**Alternative Use Boston Projects
Boston Alternative Energy Facility Order**

Planning Inspectorate Reference: EN010095

**Deadline 2 Representations by
the Environment Agency
Unique Reference Number: 20028344**

11 November 2021

TITLE
WHARF GENERAL LAYOUT
DRAWING
FIGURE 5.2 - SHEET 1 OF 3

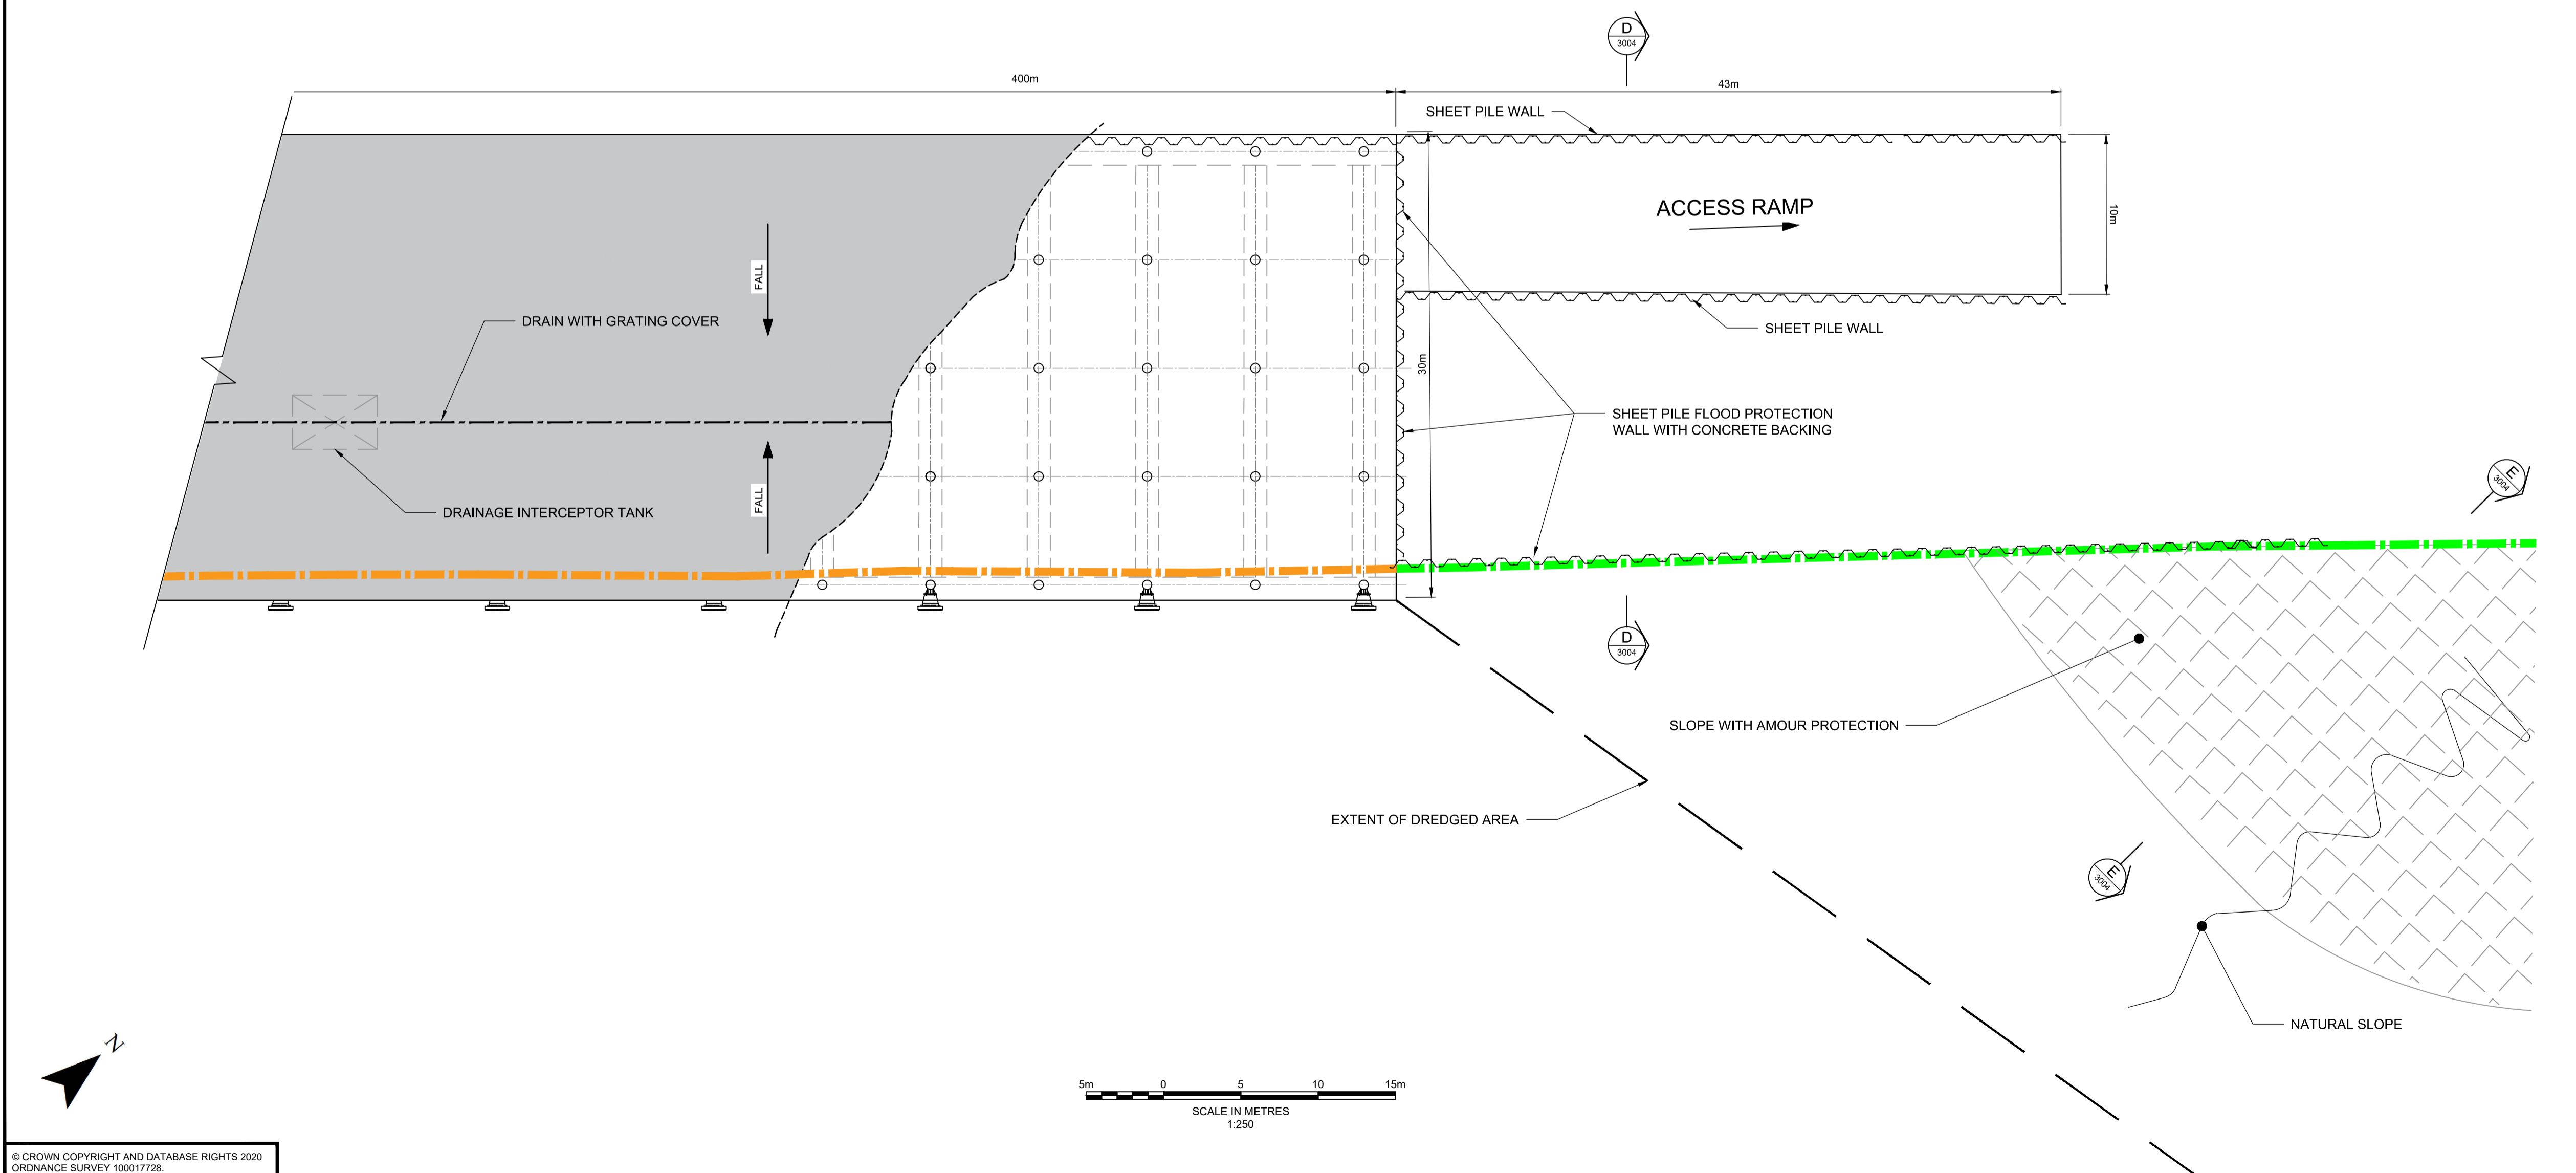
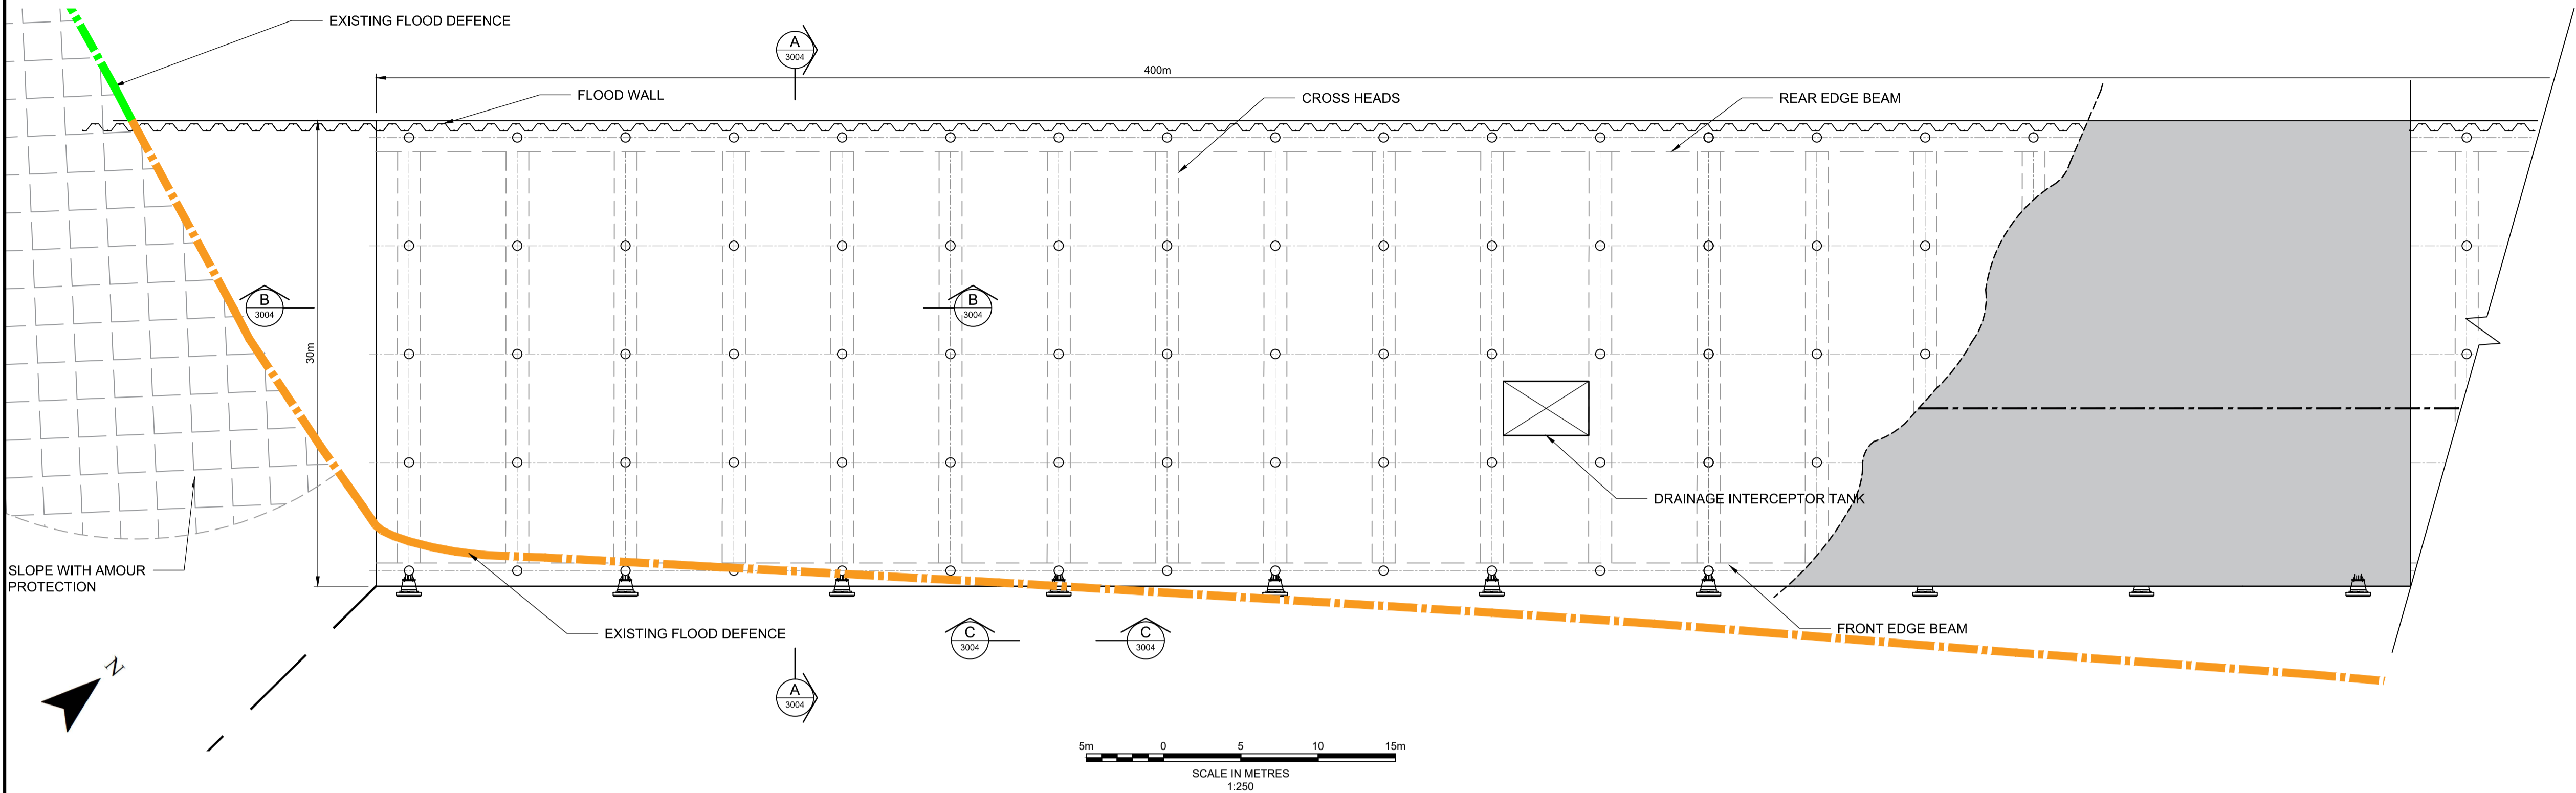
4.4. The introduction of harder surfaces from the hulls of moored vessels and the wharf structure will alter the dynamics of wave movements and may lead to more energy being exerted on the bank opposite the proposed wharf. This could lead to more rapid erosion of the bank opposite, which could affect the integrity of the defences and destroy any existing or nascent salt marsh and mudflat habitats.

4.5. We ask that the applicant provides a more detailed assessment of the impact on wave action in the area immediately opposite to ensure that the proposals do not increase the risk of flood defences failing or destroy habitats important to maintaining/improving the ecological quality of the waterbody.

- 4.9. We are concerned that the localised effects from ship wash and the proposed capital and maintenance dredging at the wharf location have not been assessed in combination. We understand that dredging is not currently carried out in the location of the proposed dredging. This suggests that very little sediment is currently deposited within the shipping channel.

- 4.10. If sediment is currently being deposited on the banks/mudflats/saltmarshes in this location, rather than the main channel, there is the possibility that dredging of the berth pocket may upset this process. The dredging may provide extra accommodation space, potentially leading to a reduction in the deposition of sediment on the channel edges. This may lead to increased erosion of the mudflats/saltmarsh opposite the proposed development site.

- 4.11. Mudflats and saltmarshes act as wave attenuation features and protect flood banks/sea walls from direct wave attack. We are concerned that the loss of these features, through erosion or dredging, may impact on the integrity of the flood defences.

- 4.12. We therefore consider that the detailed assessment of ship wash requested above should also consider the impact of dredging on the

movement of sediment in the Haven. In particular the assessment should identify whether, as a result of dredging, there would be any increase in the rate of erosion on any part of the Haven that could affect the integrity of flood defences or destroy habitats important to maintaining/improving the ecological quality of the waterbody.
